Kirklees Metropolitan Borough Council -
Development Management
HUDDERSFIELD, HD1 2JR

Reference: PA-0002960/01
Customer reference: 2026/90232
13 May 2026

Redevelopment of mill complex of 11,584sqm for mixed use development, including building demolition, site clearance, site remediation works, the removal of buildings and floor slabs to open up the River Colne, repairs to retained buildings, conversion of lower ground floor of western mill to Class E (food and non-food retail, restaurant and cafe), new buildings providing light industrial / R&D uses (limited to Use Classes Eg(ii)(iii)), the alteration and repair of an office building (Use Class Eg(i)), the creation of a new public square and associated hard and soft landscaping, circulation and servicing space, car parking and ancillary structures (within a Conservation Area) at New Mills Brougham Road Marsden Huddersfield HD7 6AZ

Environment Agency Position

**BUILDING B PROPOSED FLOOR PLANS**

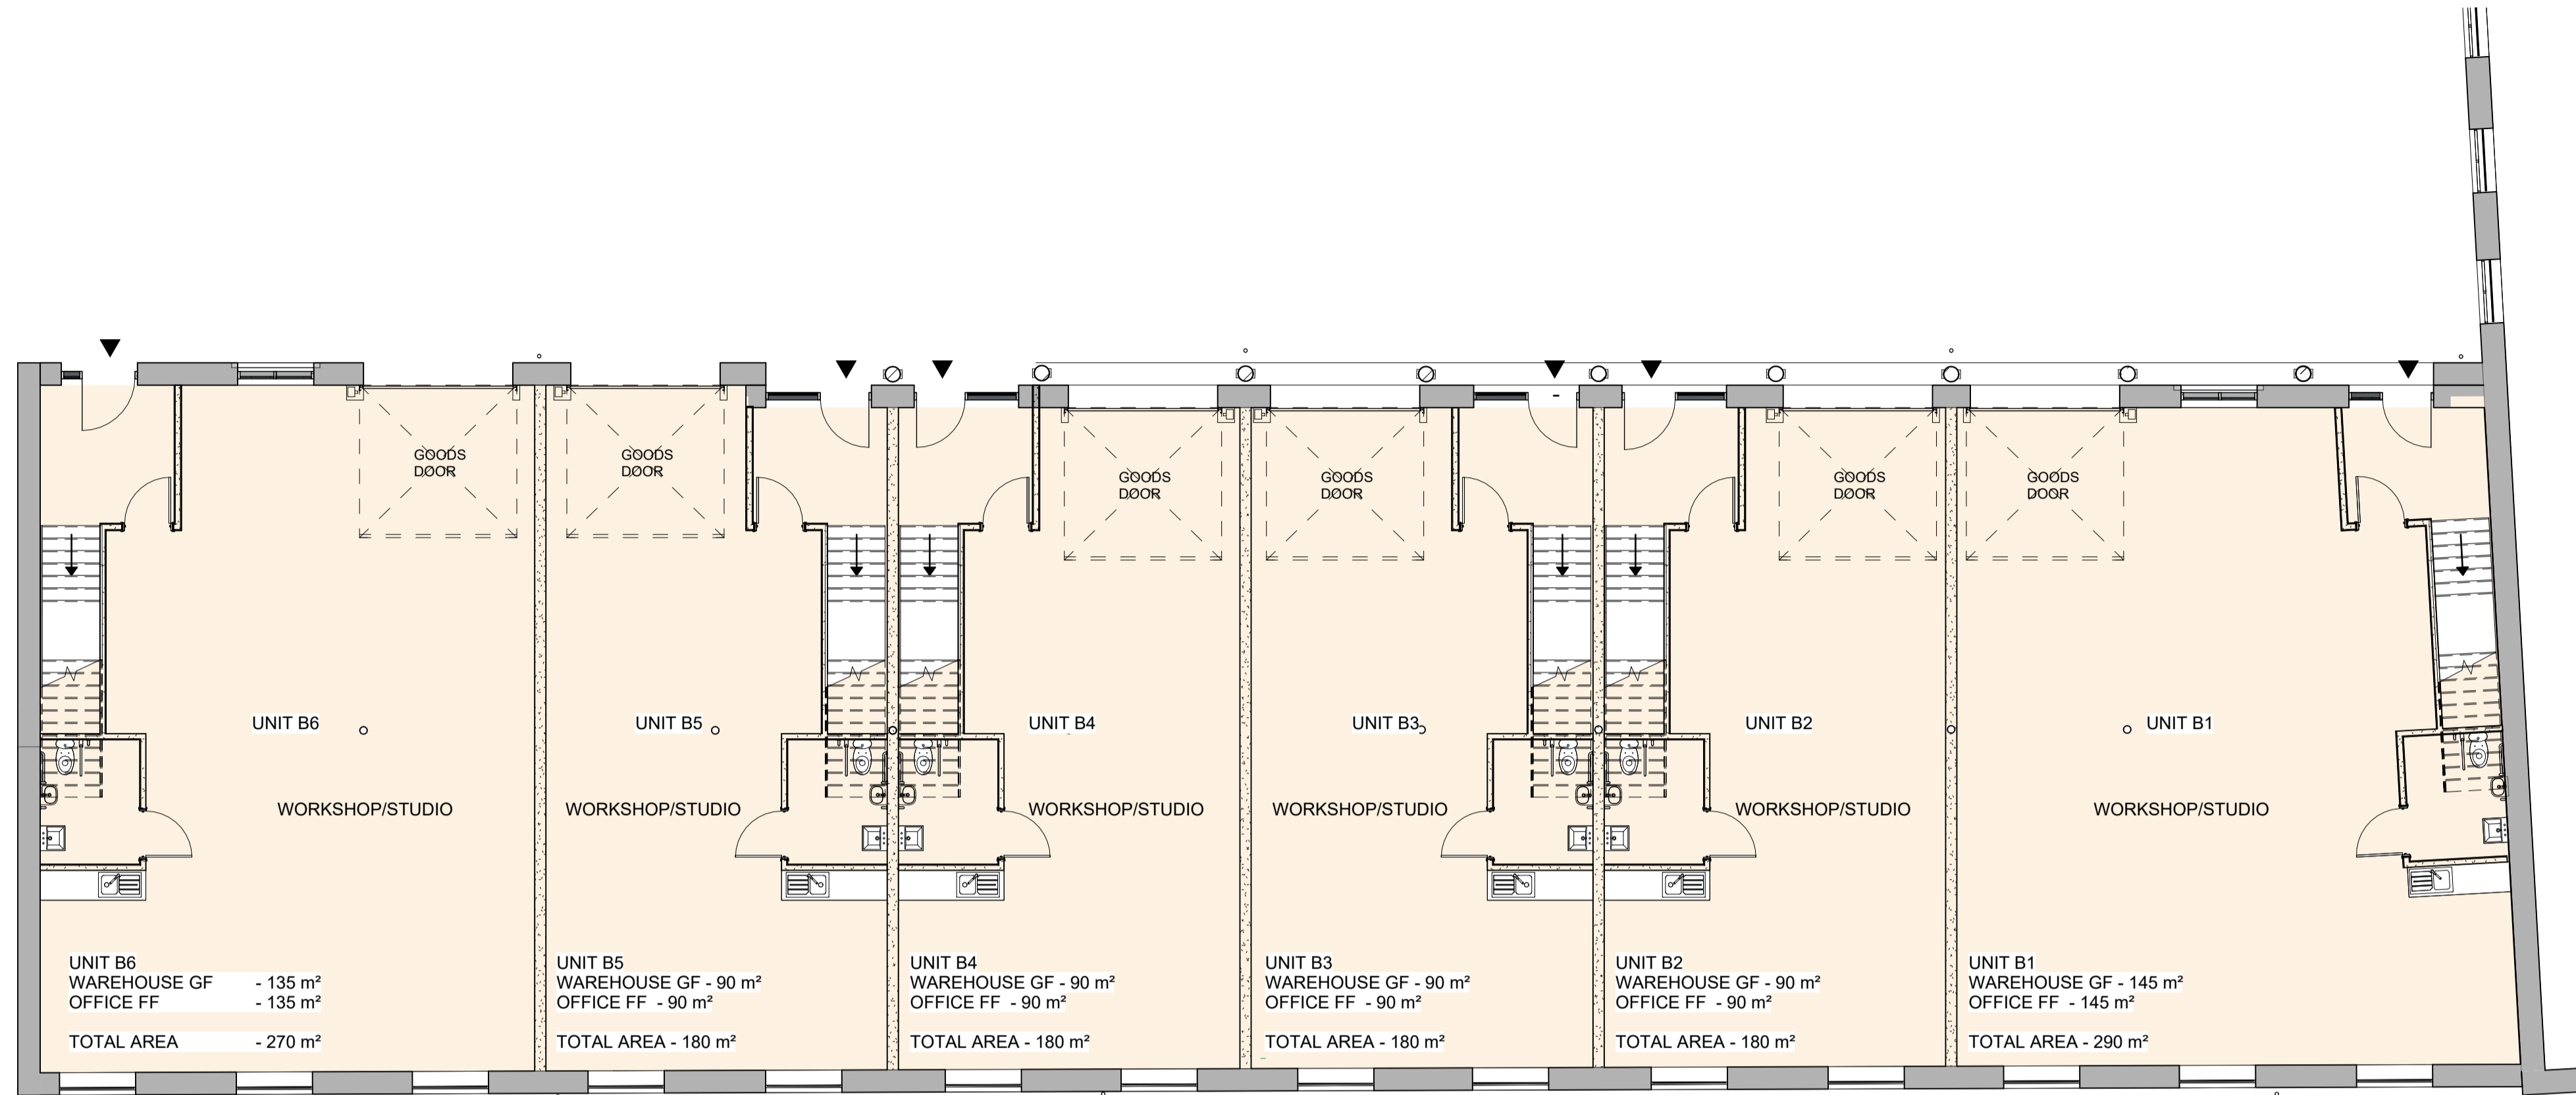
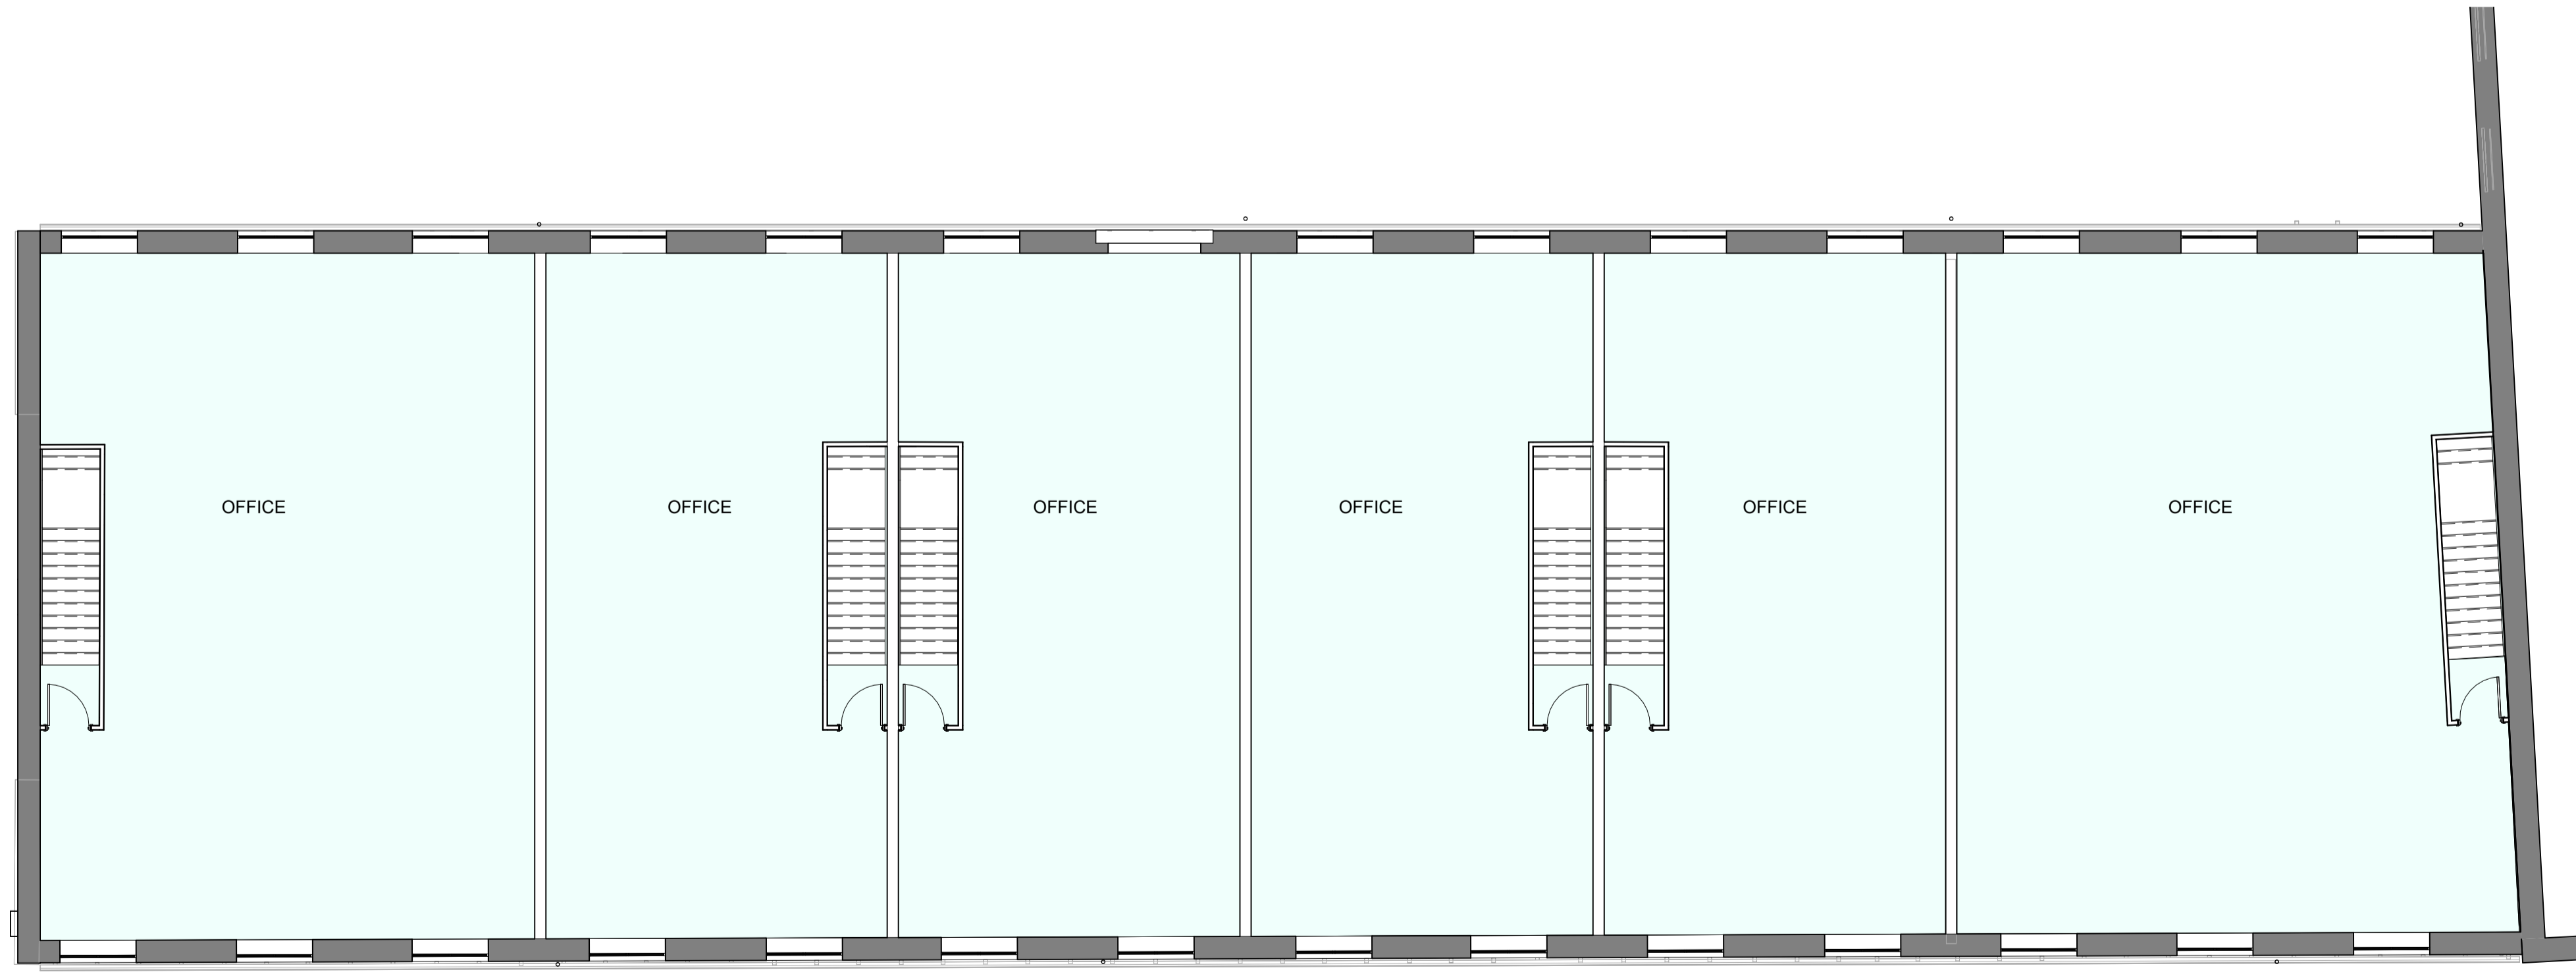
- According to our best available data, the finished floor levels for Buildings B and C are below the 1% AEP plus climate change flood level. It is unclear from the information provided whether the thresholds for the basement in the East Mill is below the 1% AEP plus climate change flood level. We also note that the FFLs noted in Drawing “23421-DCE-XX-XX-D-C-129” rev P03 dated 03/12/2025 differ to those stated in the FRA. Please note, finished floor levels should be raised 600mm above the 1% AEP plus climate change flood level.
- The proposed mitigation should also take into account any impacts from deculverting the River Colne.

To overcome our objection, the applicant should submit a revised FRA which addresses the points highlighted above. If this cannot be achieved, we are likely to maintain our objection. Please re-consult us if a revised FRA is submitted and we will respond within 21 days of re-consultation.
